COLORADO GEOLOGICAL SURVEY

August 8, 2017

**Subject: Settlers View Subdivision (EA Number EA16-43, File Number SP17006),
El Paso County, CO; CGS Unique No. EP-17-0060**

SETTLERS VIEW SUBDIVISION  
Preliminary Plat  
El Paso County, Colorado

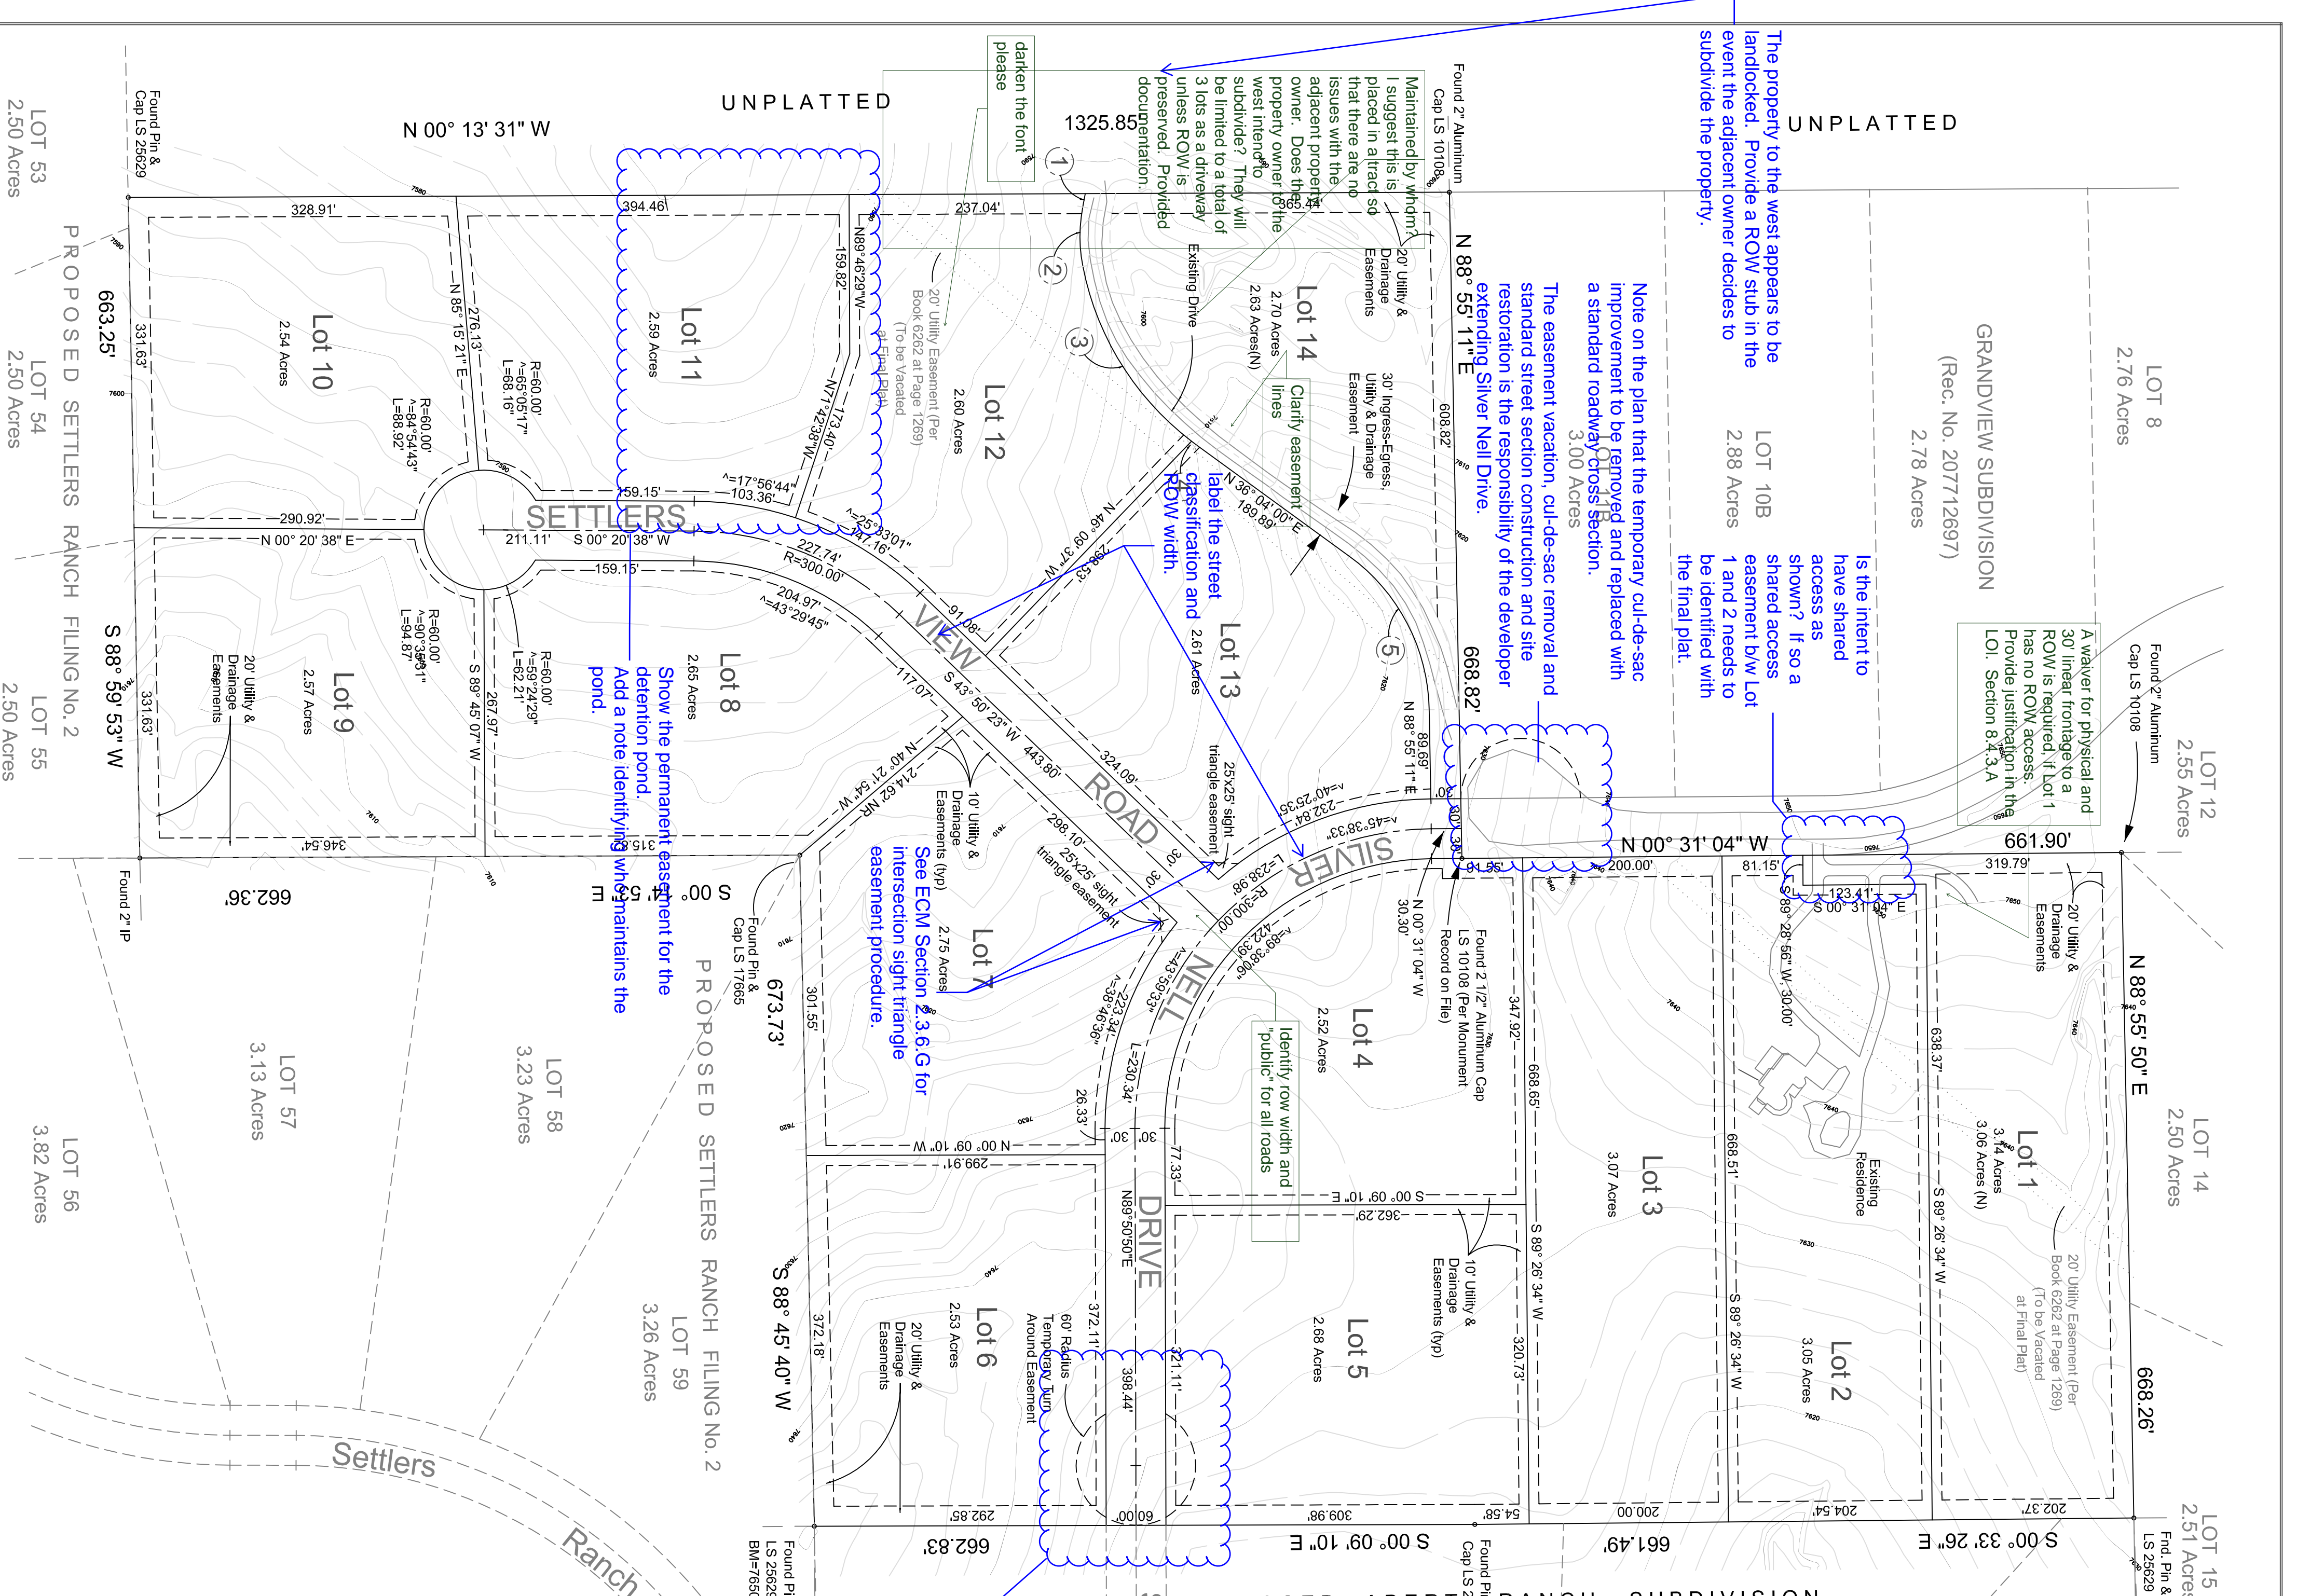
Site Drainage. The drainage report prepared by JPS Engineering states that “Developed flows from the subdivision will be detained to historic levels through an on-site private stormwater detention pond.” A detention pond is shown within the development as shown on Sheet D1.1 that appears to be located in Lot 11 of the Preliminary Plan. *This proposed detention pond should be shown on the Preliminary Plan.*
